WEST SUSSEX COUNTY COUNCIL CONSULTATION

TO:	Arun District Council FAO: Mr S Davis
FROM:	WSCC - County Highways
DATE:	13/03/2018
SUBJECT:	BE/16/18/PL Relocate existing cycle shelters, installation of 1 No. portacabin & 2 No. smoking shelters in a fenced off compound. Rolls-Royce Technology & Logistics Centre, Newlands Road, Bognor Regis, PO22 9FJ
DATE OF SITE VISIT:	n/a
RECOMMENDATION:	Advice & More Info
S106 CONTRIBUTION TOTAL:	n/a

Drawing Title
Existing Site Plans

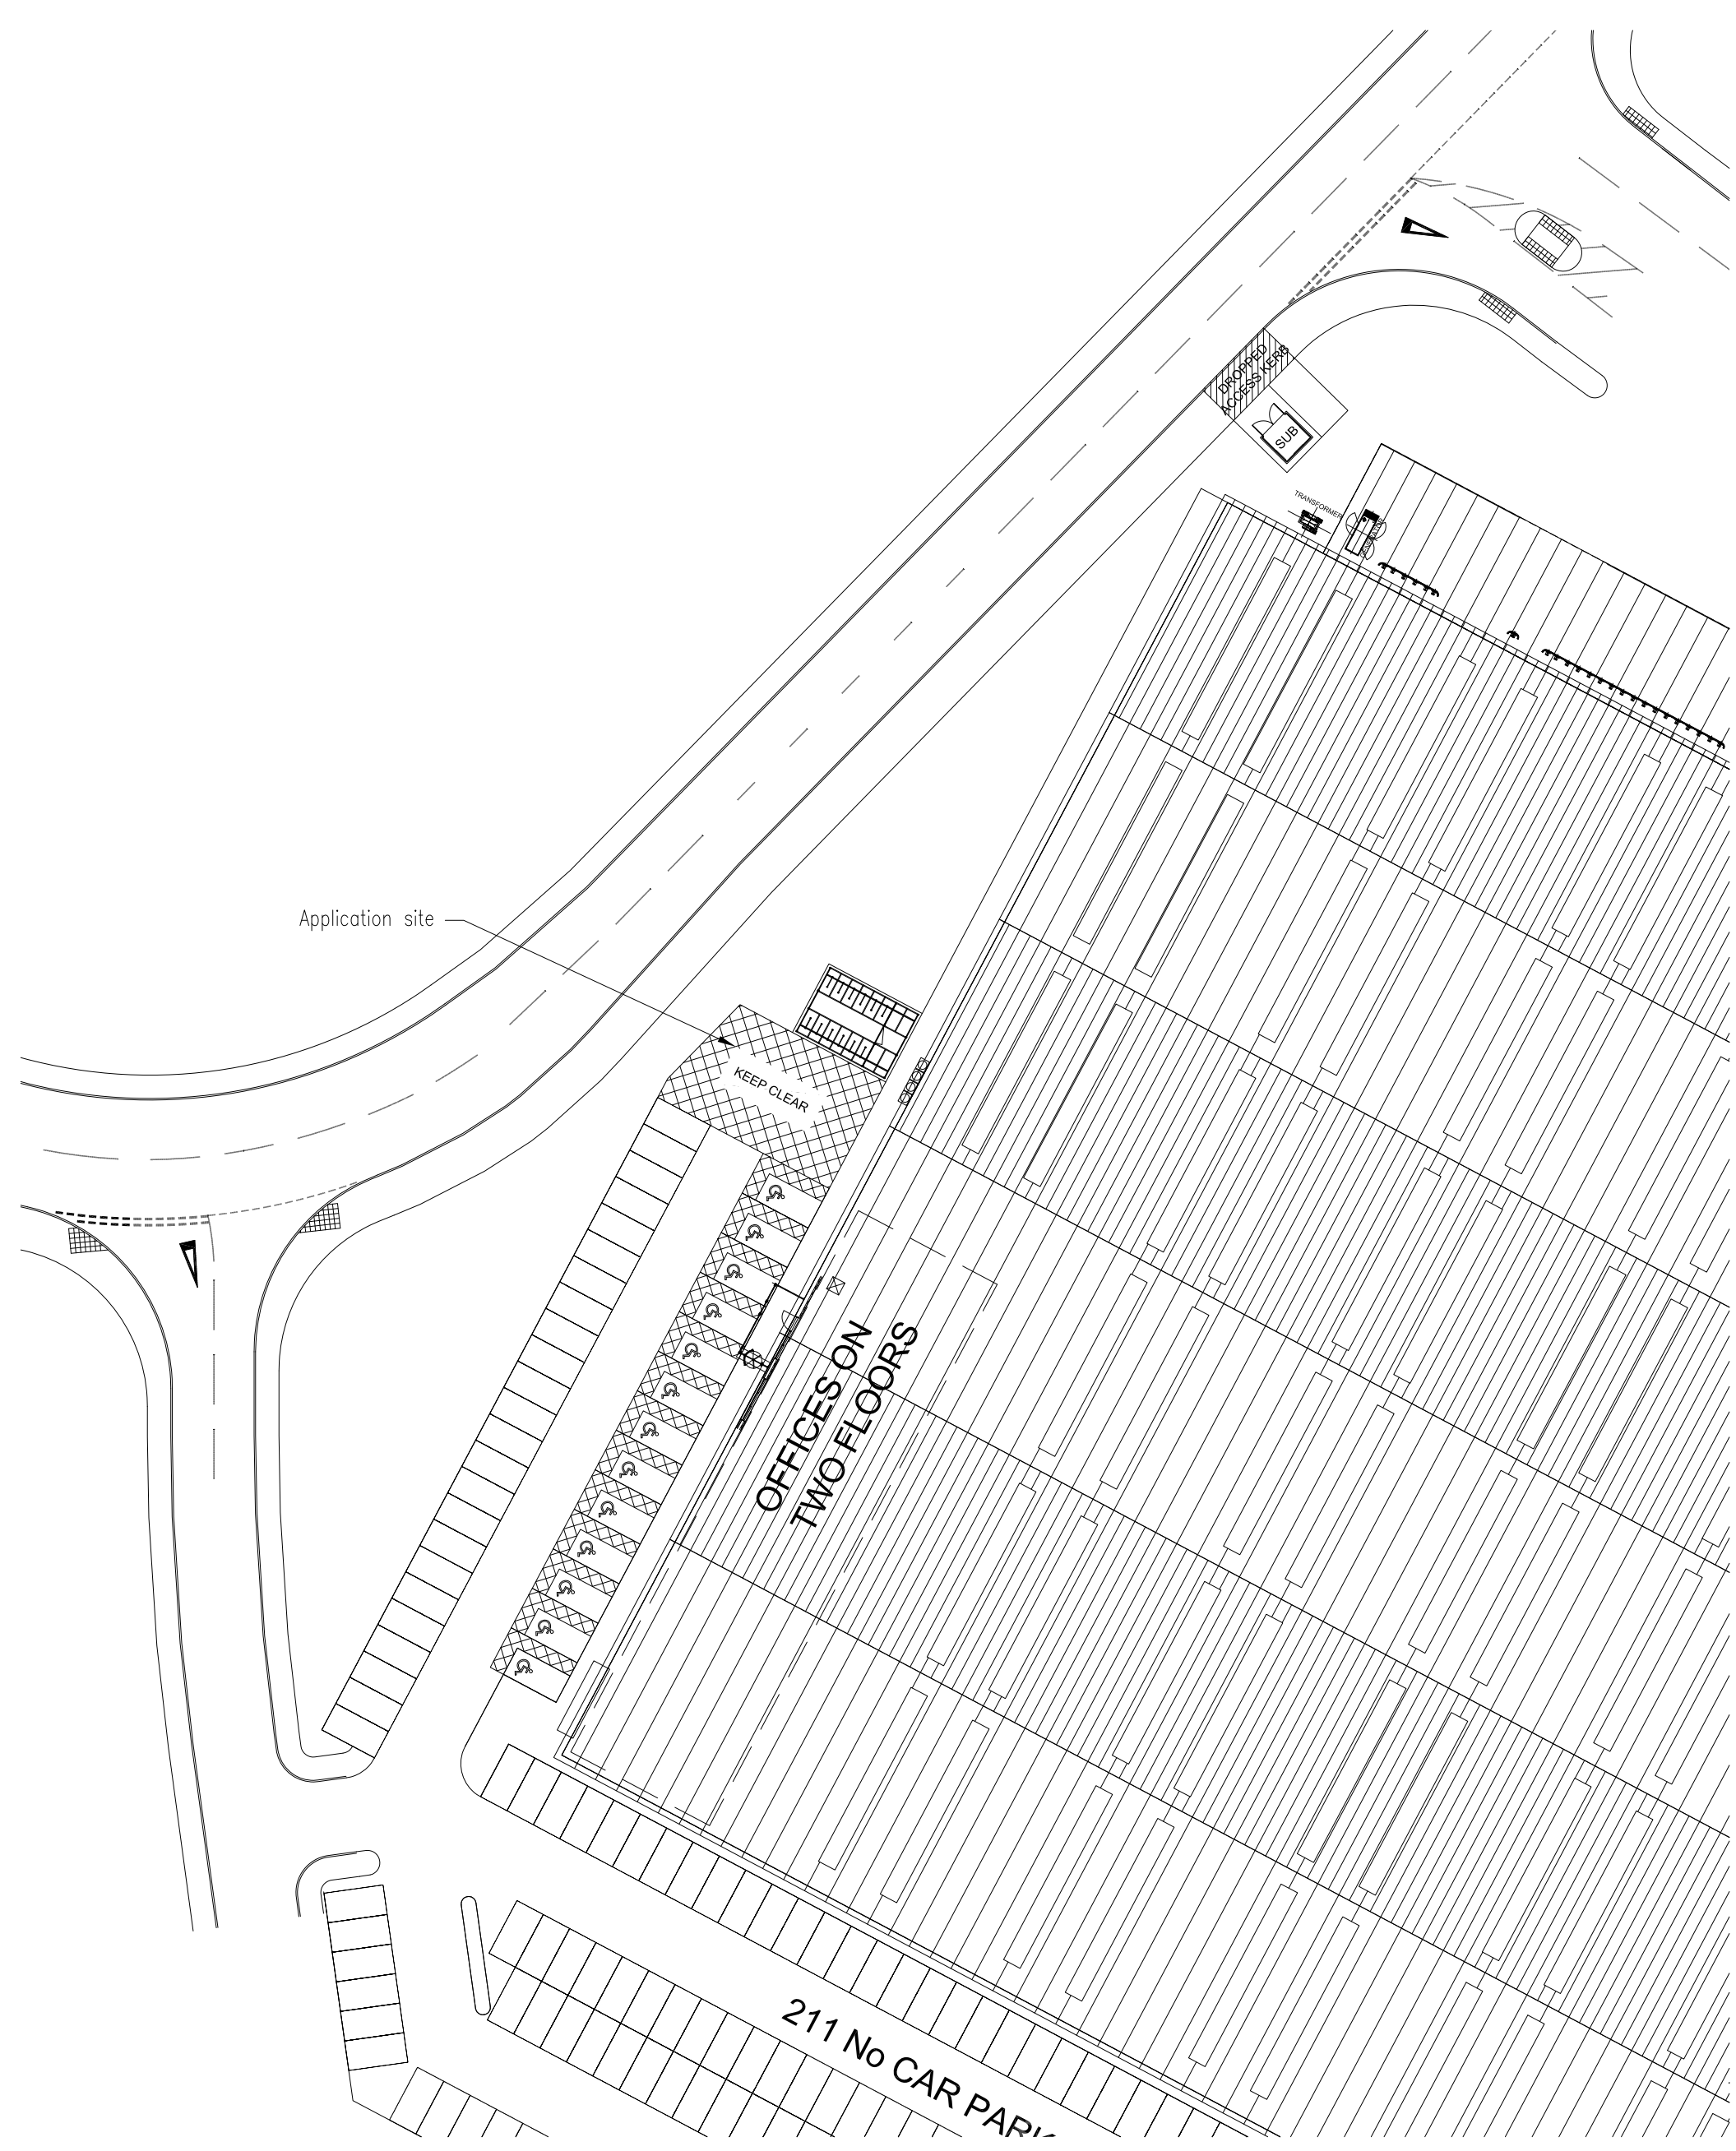
The proposed will result in the loss of two disabled parking bays.

WSCC advises that 5% of all spaces at places of employment are disabled accessible. I would be minded to ask that the applicant clarify the total parking provision on site to ensure this is still the case.
